Appeal Decision

Appeal Ref: APP/R4408/W/17/3175804

Ivy Cottage, 108 Upper Hoyland Road, Hoyland, Barnsley, S74 9NL

FRONT ELEVATION

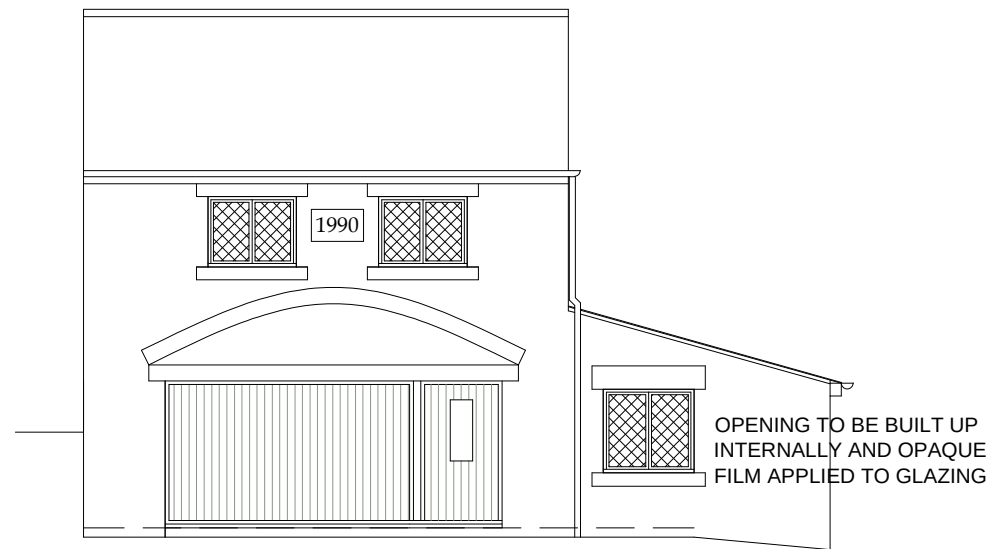
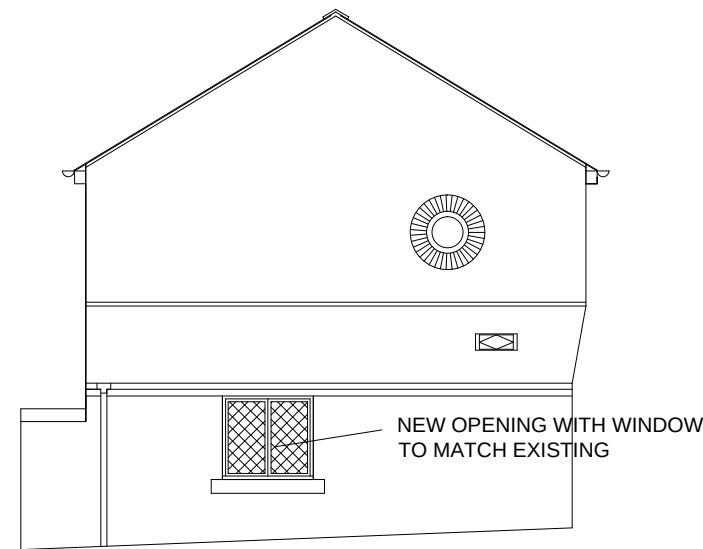
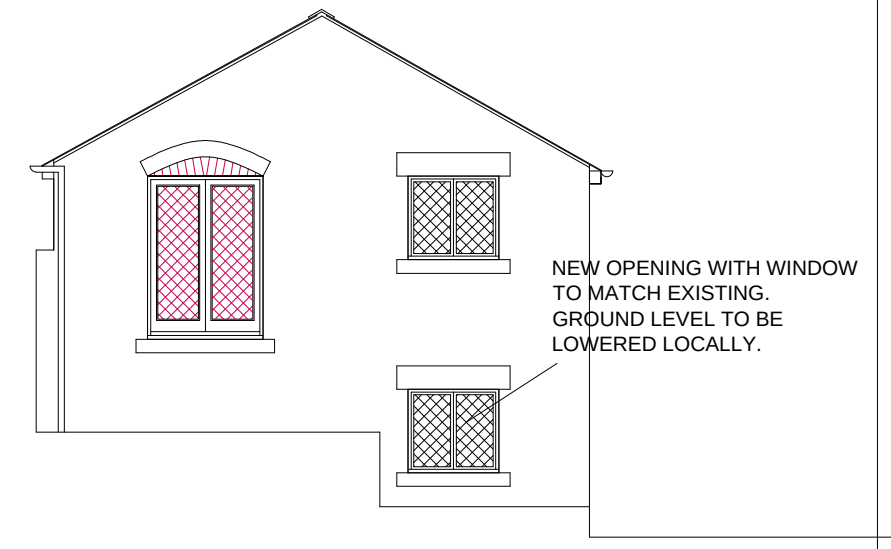
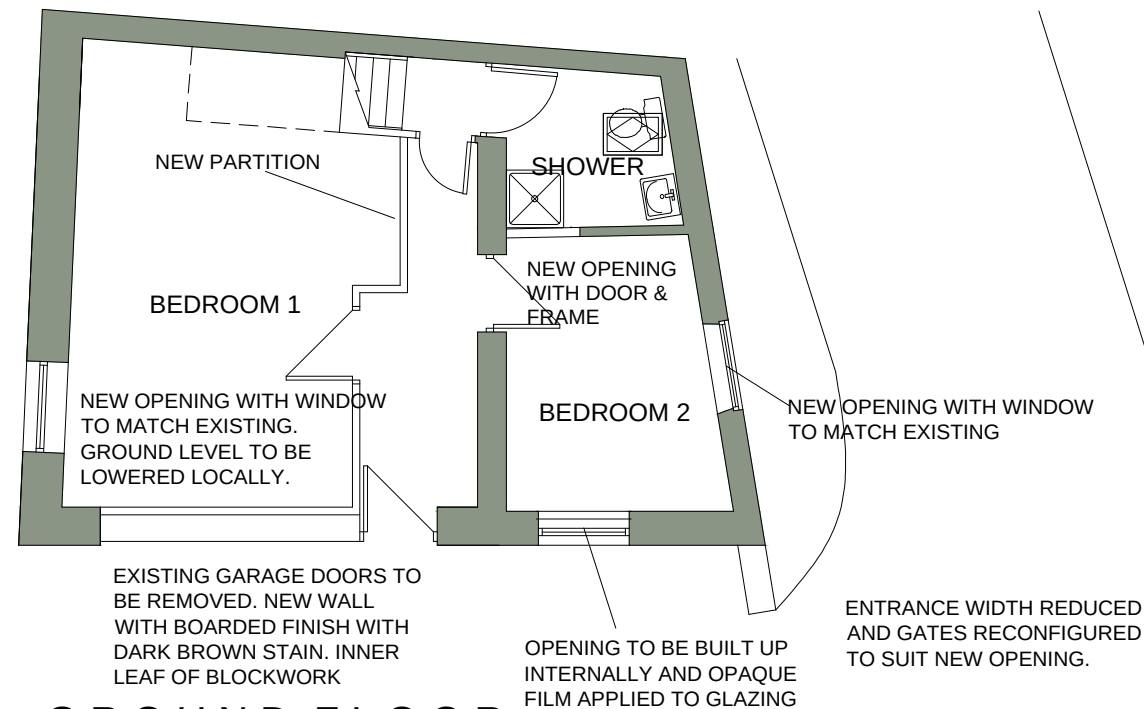
4. The 3 windows in the appeal building's eastern elevation would be built up internally, and opaque film would be applied to the glazing. The retention of obscured glazing could be secured by condition. These measures would ensure that there would be no direct overlooking to the existing windows in the western elevation of No 108. Whilst I note the minimum separation distances stipulated in the Council's Designing New Housing Development Supplementary Planning Document (SPD), in this case the appeal building already exists. Accordingly, the conversion would not result in any loss of light or outlook to windows in No 108, over and above the existing situation. Accordingly, the failure to meet the SPD separation distances is not critical in this case.

8. Whilst the 3 windows in the appeal buildings eastern elevation would be built up internally, other new openings would be created. Each of the ground floor bedrooms would be served by a large window that would provide adequate light and outlook. The first floor lounge/kitchen/dining area would also be adequately served by 2 large windows in the southern elevation of the building, as well as a smaller window to the northern elevation.

- 4) Prior to the first occupation of the proposed dwelling, the windows in the eastern elevation of the building facing 108 Hoyland Road shall be fitted with obscured glazing and shall be retained as such thereafter.

- 5) Notwithstanding the provisions of the Town and Country Planning (General Permitted Development) (England) Order 2015 (or any order revoking and re-enacting that Order with or without modification), no windows other than those expressly authorised by this permission shall be constructed on the eastern elevation of the dwelling hereby permitted.
